City of Albuquerque

RE: Grading and Drainage Plan for Edith Blvd. and Granite Ave. NE (J-14/ D141), Engineer's stamp dated July 30, 2001. (J-14,15)

FILE: 010401 - GAHP-CRESPIN -SITE		DRAINAGE AND GRADING PLAN FOR EDITH BLVD AND GRANITE	
Applied Engineering & Surveying, Inc. 1605 BLAIR DRIVE NE ALBUQUERQUE, NEW MEXICO 87112 PH: (505)237-1456		DATE/REVISIONS:	SHEET NUMBER: 1

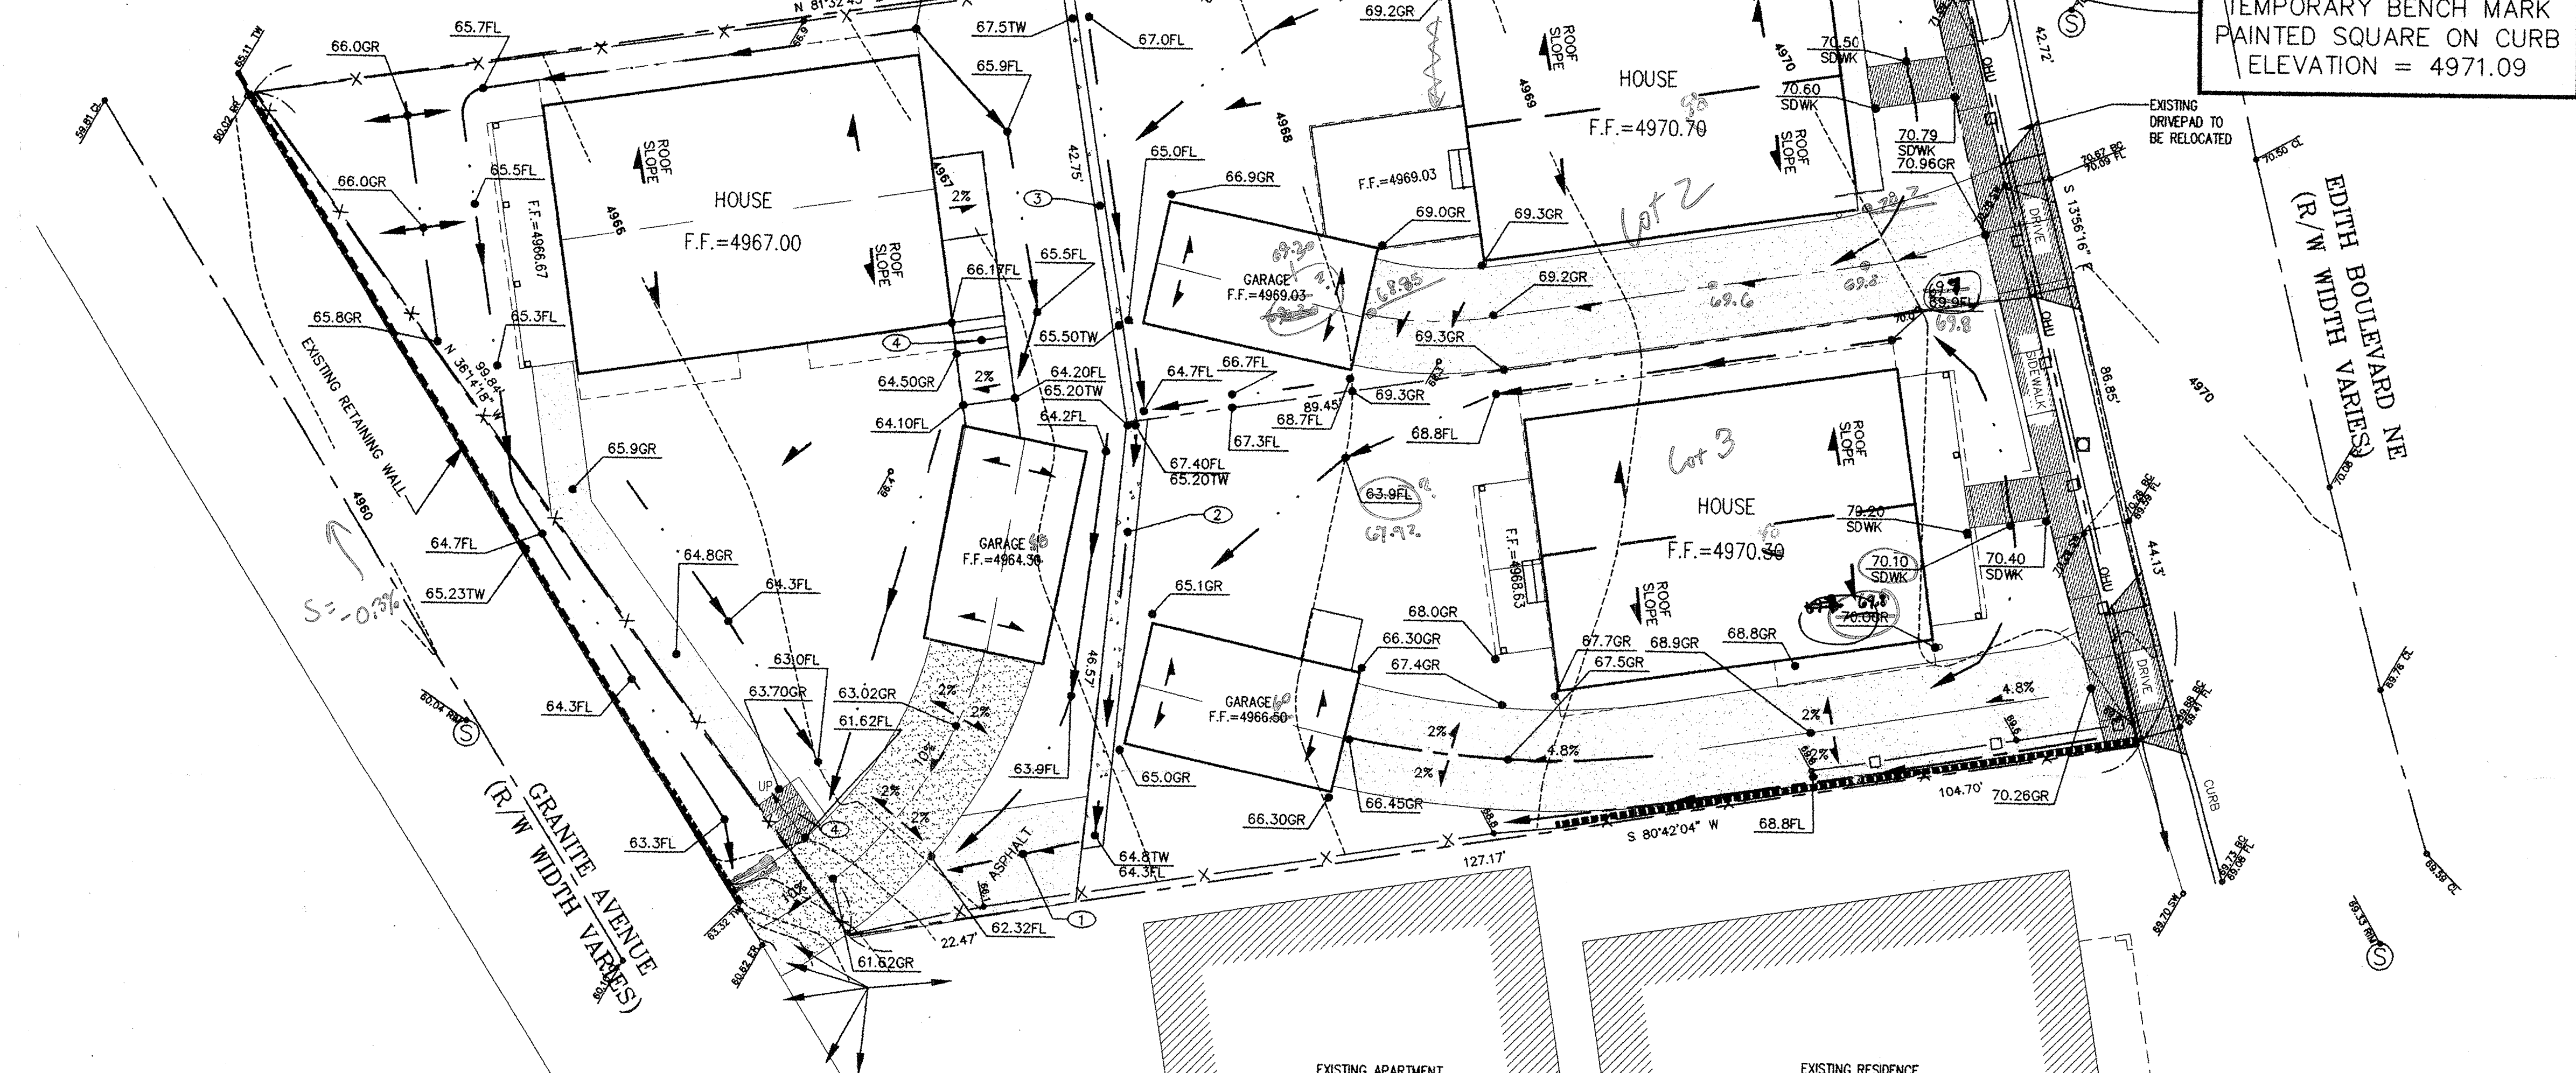
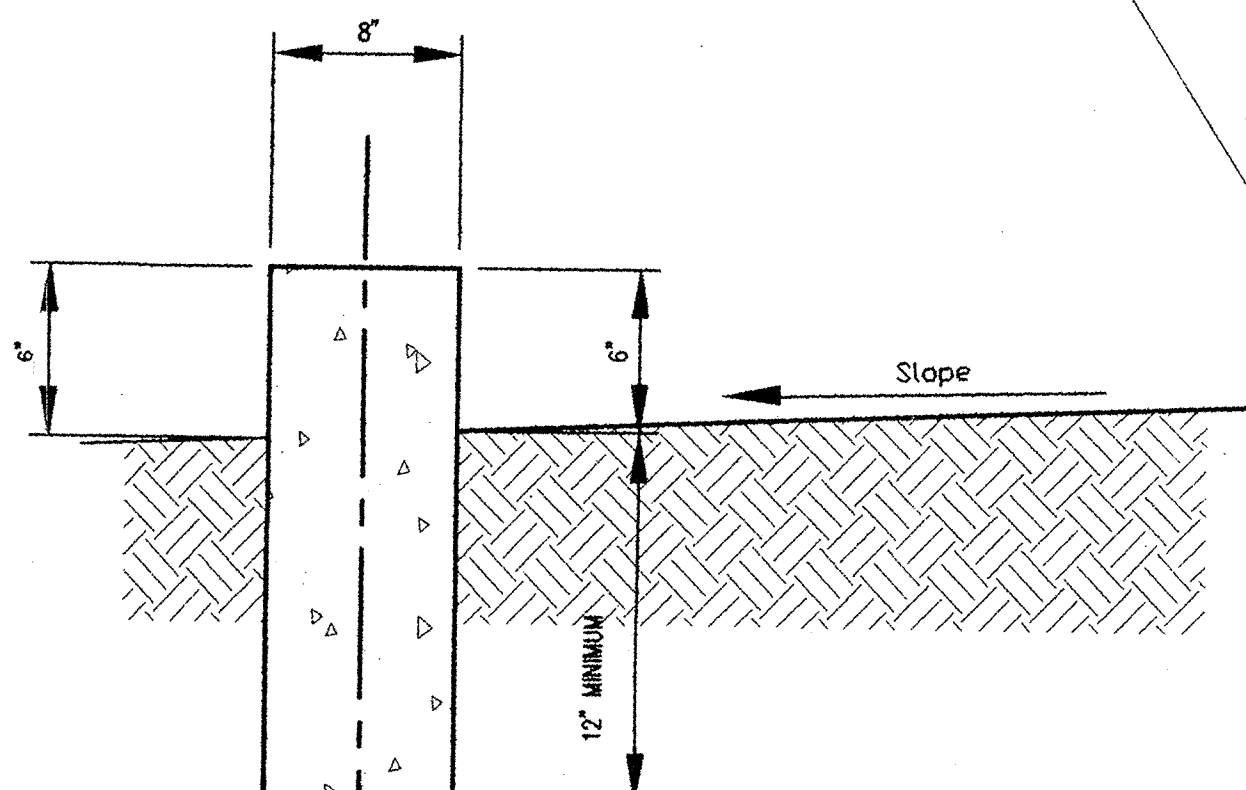
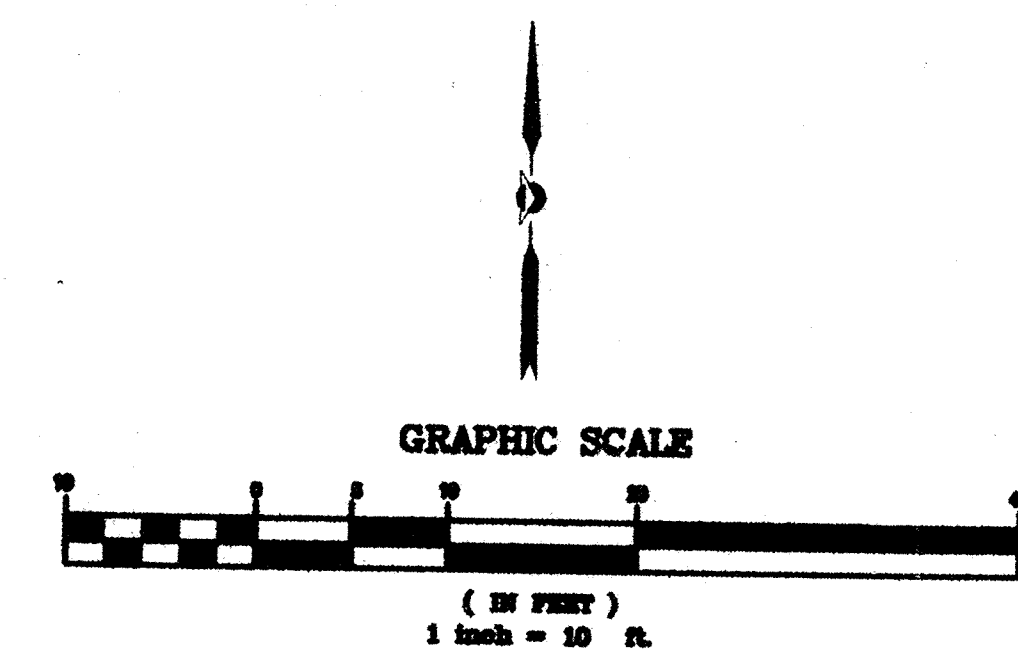
- ✓1. Please label the lots. Lots 2 and 3 are referred to in General Note 1, but are not shown.
- ✓2. Please add some steel to the proposed flood wall. A suggested design: Use #4 bars. Vertical bars @24" OC. Horizontal bars @top and bottom of wall, minimum 3" cover.

- ✓3. Please add a spot elevation of 70.2GR at the southeast corner of the house on Lot 2.
- ✓4. The garage in Lot 2 has finish floor elevation of 4969.03. This seems too low based on the spot elevation of 69.0GR at the northeast corner of the garage. Please raise the garage finish floor to 4969.30 and add spot elevations in the centerline of the driveway to show where the runoff crosses the gravel driveway.

- ✓5. Please raise the garage finish floor of Lot 3 from 4966.50 to 4966.60.
- ✓6. I assume that the lot on the west side of the site is Lot 1. Please label. Raise the finish floor of this garage from 4964.30 to 4964.40.

- ✓7. Is the driveway leading to Granite Avenue concrete or gravel? Please label. If it is gravel, how do you propose to control erosion at the 10% slope area? The gravel will end up washed into Granite Ave. If it is concrete, please add a 5-foot long 18-inch deep concrete cutoff wall under the driveway on its north edge where it meets the retaining wall so that the driveway does not get undermined from the runoff that will discharge across it to get to Granite Ave. You can use similar concrete thickness and steel as the flood wall.

- ✓8. There is spot elevation labeled "63.9FL" in the swale in the backyard of Lot 2. This is not right and should be 67.9 instead, as best as I can tell. Please revise.

- ✓9. What is the thickness of the "V" swale concrete? Please add to plan.
- ✓10. What is meant by the group of arrows at the southwest corner of the site?
